Recommendation Report for Planning Permission for Works or Extension to a Dwelling

REF NO: P/26/22/HH

LOCATION: 123 West Front Road
Pagham
PO21 4TB

PROPOSAL: Single storey front extension, incorporating demolition of existing lean-to.

PROPOSED FLOOR PLAN

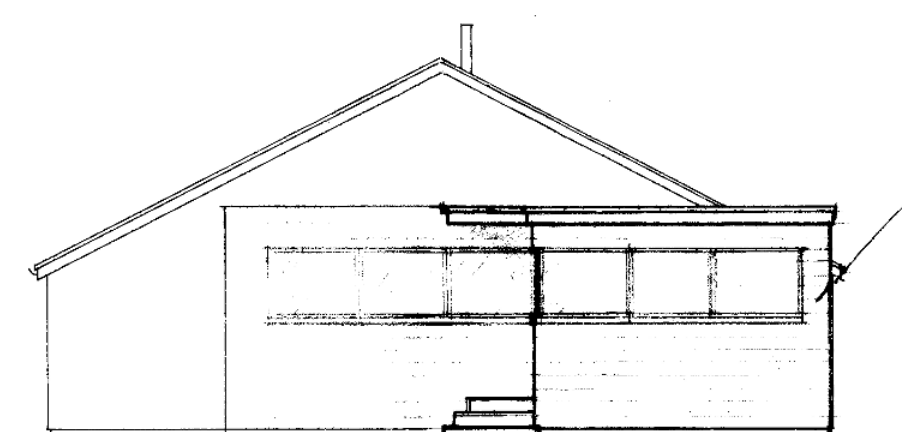
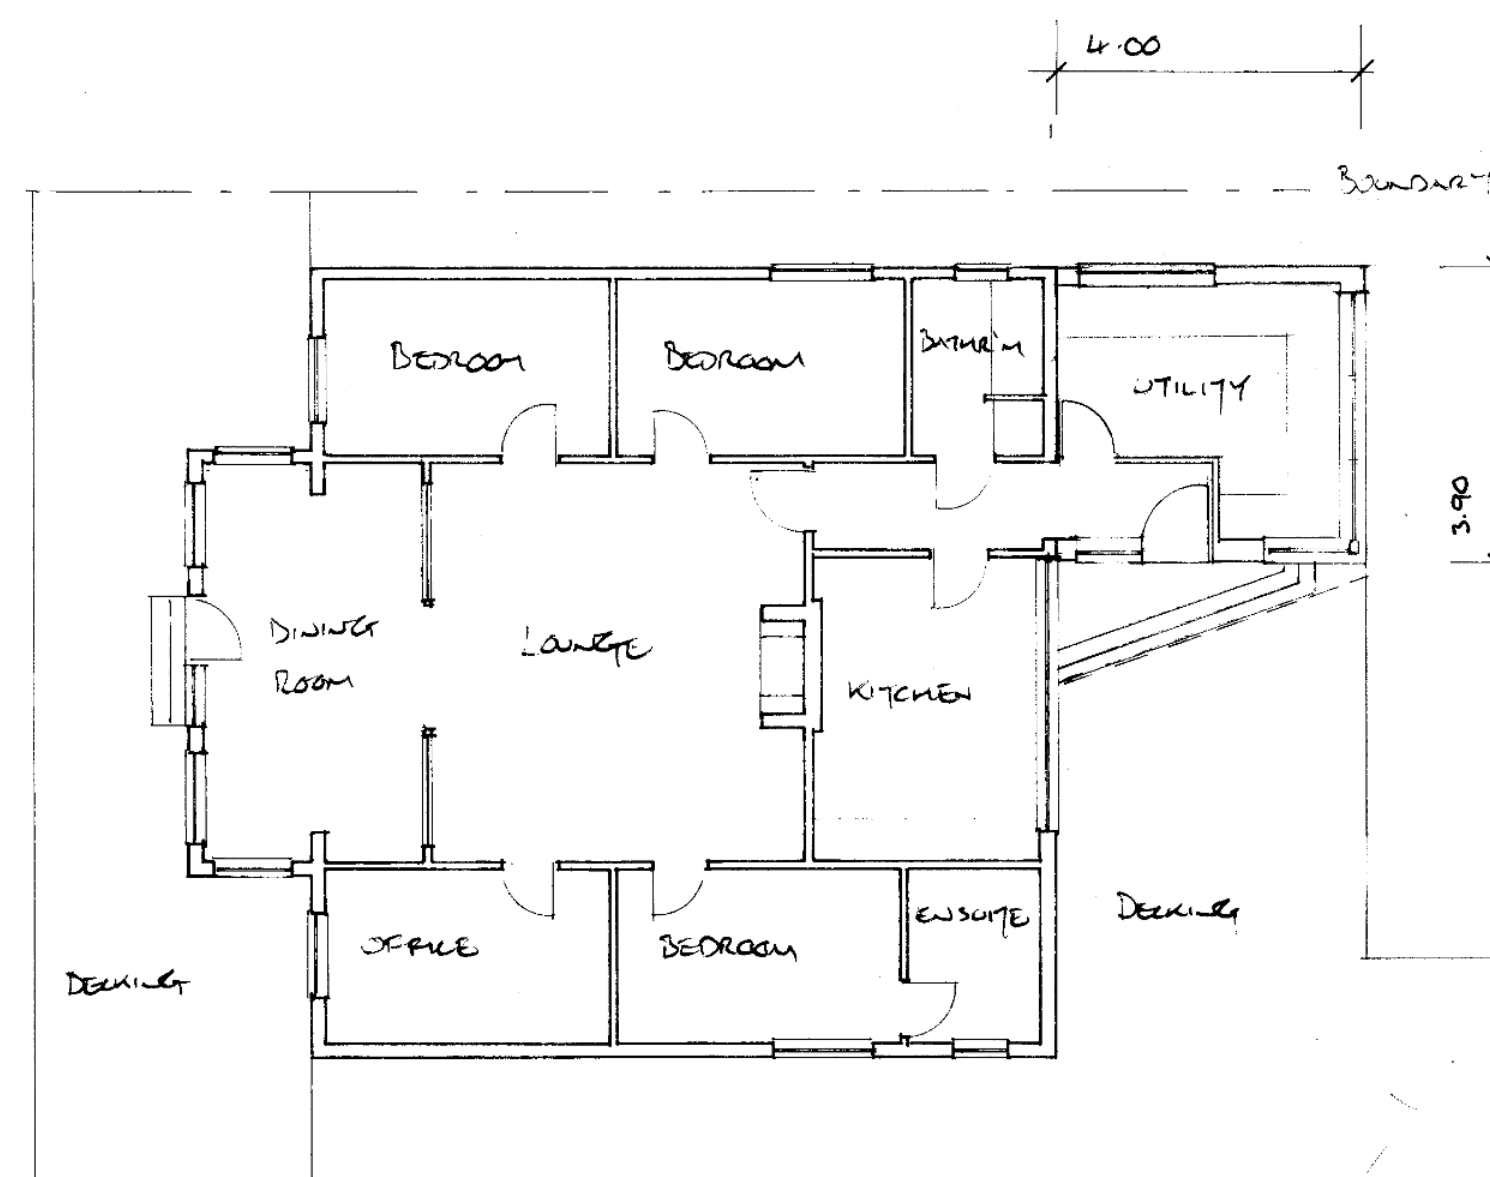
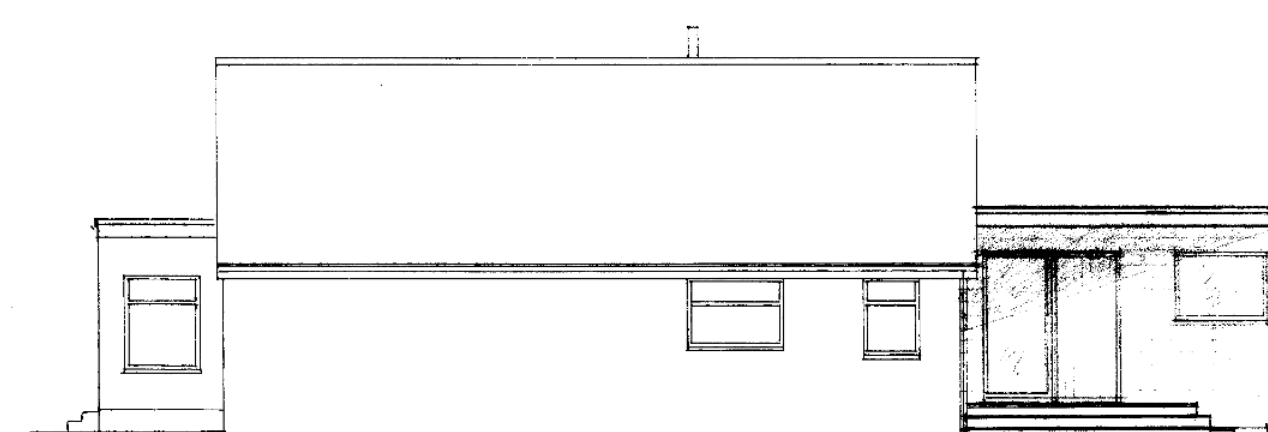
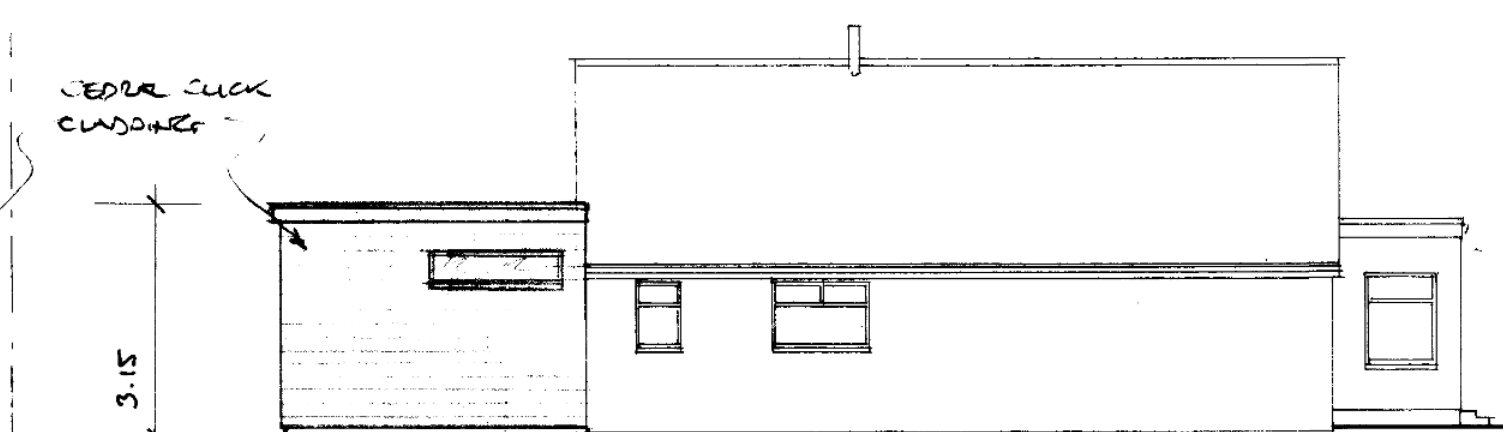
The extension is modest in size with a depth of 4m. This does not extend beyond the established development line and retains 26m to the front boundary. The proposal will have a flat roof and appears subservient to the dwelling.

The external materials will consist of cladding. This is in contrast to the dwelling which features rendered blockwork however, with the extension modest in size, the material will not result in harm to the appearance of the dwelling and is appropriate for its setting.

The Arun Design Guide states 'Extensions should not project forward beyond the predominant building line'. 'Front extensions should generally be no deeper than 1.5 metres'. The proposal complies in part as it does not extend beyond the building line. It is deeper than 1.5m although with sufficient separation to the front boundary, this is considered acceptable.

The proposal will extend 4m from the front elevation with a width of 3.9m. It will have a flat roof with a height of 3m. The extension retains 1.4m to the south western boundary and does not intersect a 45 degree angle from the windows closest to the boundary. 7.9m is retained to the north east and as such the proposal will not result in adverse harm on amenity by way of overbearing or overshadowing.

There is one window to the extension to the south west, although with it serving utility and at ground floor level, it will not give rise to adverse overlooking.

SITE 1:500

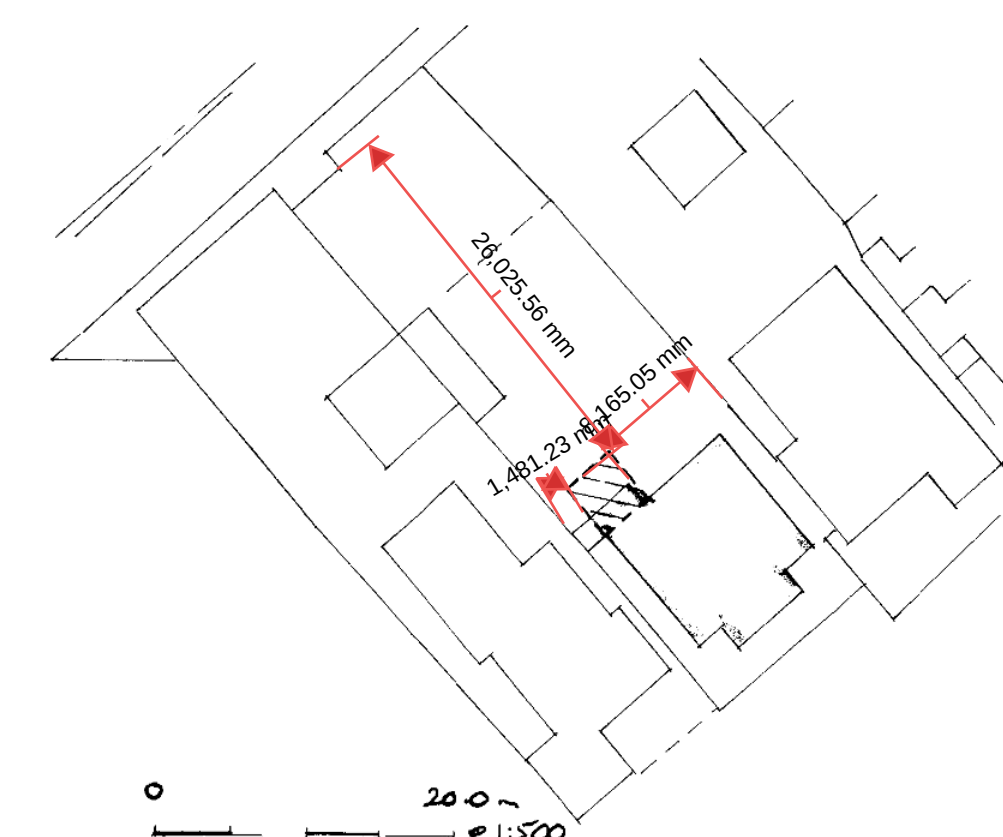
Part of the site falls in Flood Zone 2 and 3 however the development is outside of these areas. On the 6th October 2021, The Planning Policy Committee agreed a new interim framework for assessing planning applications at Pagham while the implications of Coastal Change Management Area (CCMA) are explored.
